RE: Juan Tabo Hills Estates Preliminary Plat, Project # 1005278

The purpose of this letter is to explain how the comments as contained in the DRB Official Notice of Decision (May 21, 2015) have been addressed. The following items have been revised and are being re-submitted for review and approval.

NEW STORM SEWER EASEMENTS

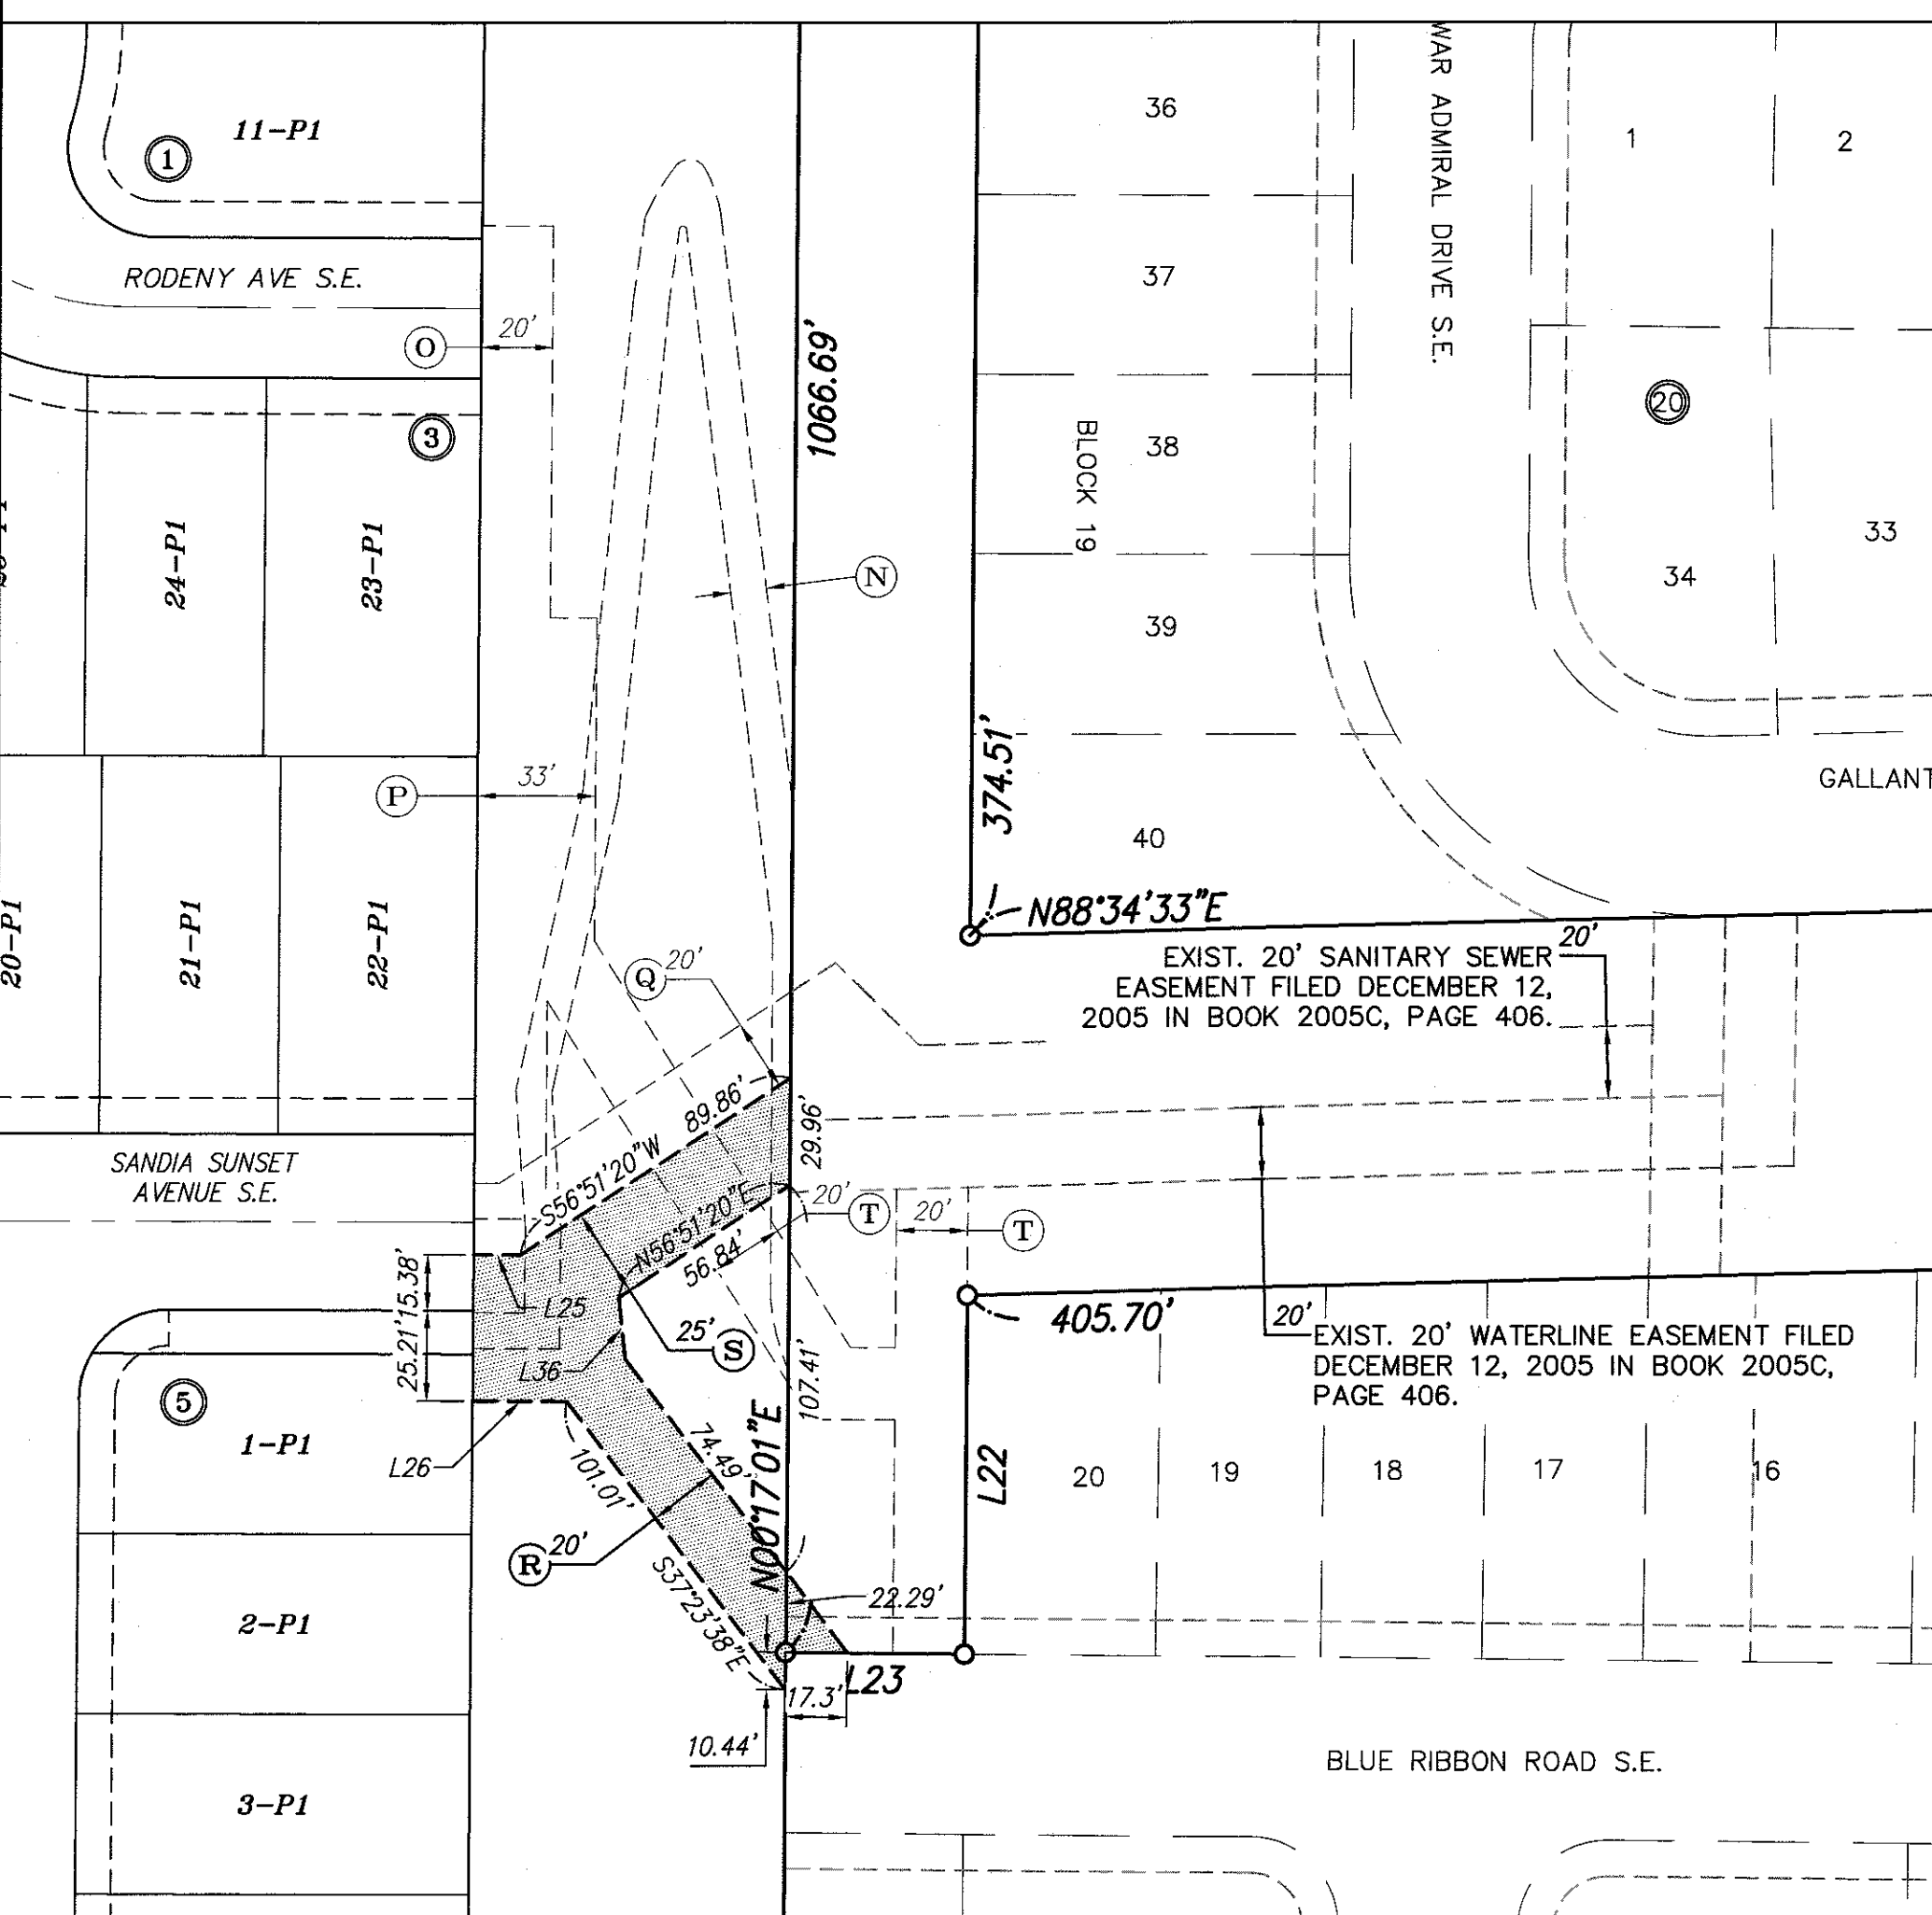
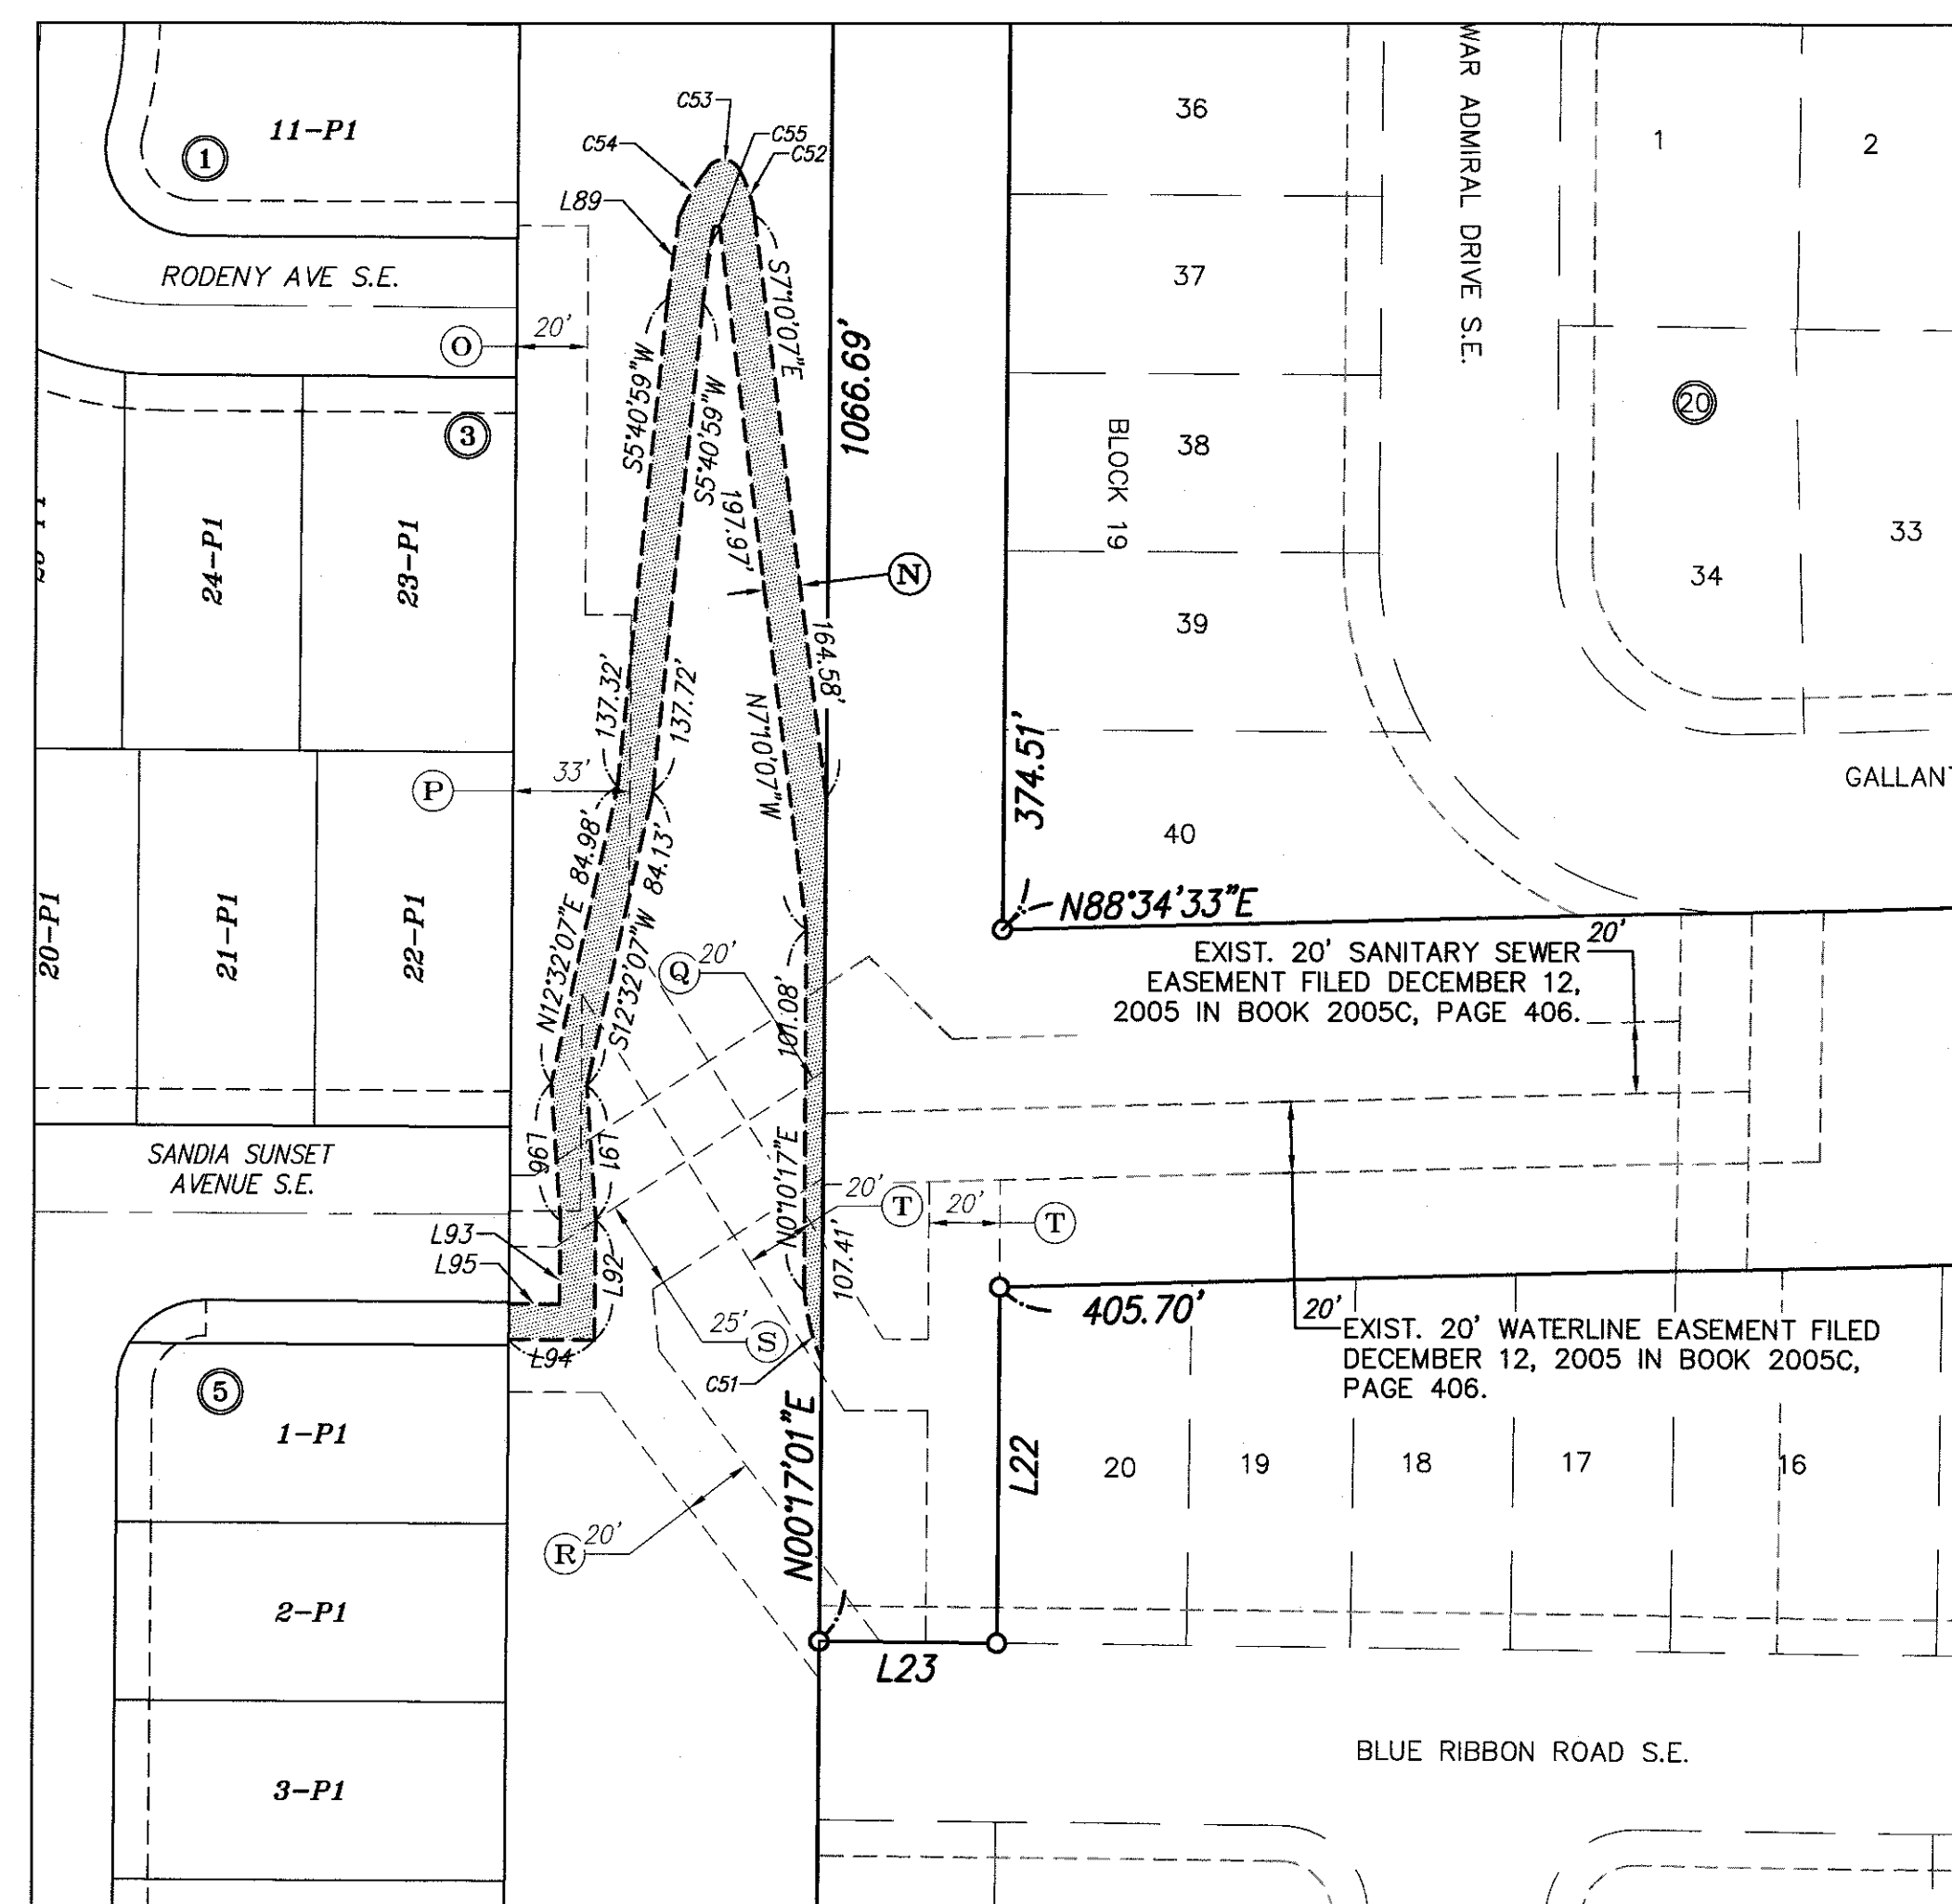
ABCWUA comments (1.) A development agreement has been submitted to ABCWUA for Board approval. It should be introduced to the Board at the October 21 meeting and then hopefully approved at the following meeting on November 18. (2.) Mark Goodwin is not willing to provide an acknowledgement letter. (3.) Site Plan comments are not applicable since the Conceptual Utility sheet has been removed from the Site Plan. However the Conceptual Utility Plan has been updated and provided as an aid to review of the Preliminary Plat and the Infrastructure List. (4.) The Infrastructure List has been revised by (4.i) changing the 8" water lines to 10" in Pocono Rd, Silver Dollar St, Manzano Vista Ave, Rock Squirrel and Sandia Sunset, (4.ii) 8" water line connection added between the existing line in Blue Ribbon Rd and the existing line in Tract 1-A-1-B which connects to Gallant Fox Rd., (4.iii) the 6" waterline in the stub on the south end of Hubbard remained 6" on the infrastructure list and was changed to 6" on the Conceptual Utility Plan, (4.iv) the north end of the Canyon Wren water line was changed to 8", (4.v) the 6" water lines in stub streets were changed to 4" water lines, (4.vi) the White Dove St. water line was changed from 6" to 8", (4.vii) the removal of the existing 21" SAS was added, (4.viii) the removal of the existing 8" SAS in Tract 1-A-1-B was added, and two Pressure Reducing Stations were added to the Infrastructure List. (5.) The Preliminary Plat was revised by adding the Vacation of a portion of Tract D to Sheet 1, and by separating the storm easements from the sanitary and waterline easements.

added to the Grading Plan. Separate permits will be obtained from the Corps of Engineers and AMAFCA that will address fencing along the arroyo. (6.) Ten foot wide AC Trails have been added to tracts H and J and are located in the best place available to insure privacy of the residents. AMAFCA has no objection to the approval of the Preliminary Plat and will be reviewing more detailed plans after Preliminary Plat Approval keeping in mind federal water quality standards and regulations.

streets are wide enough to accommodate on street parking. Finally the 4' sidewalks were changed to 10' wide AC trails in response to DMD comments and the 2040 Long Range Bikeway System Map.
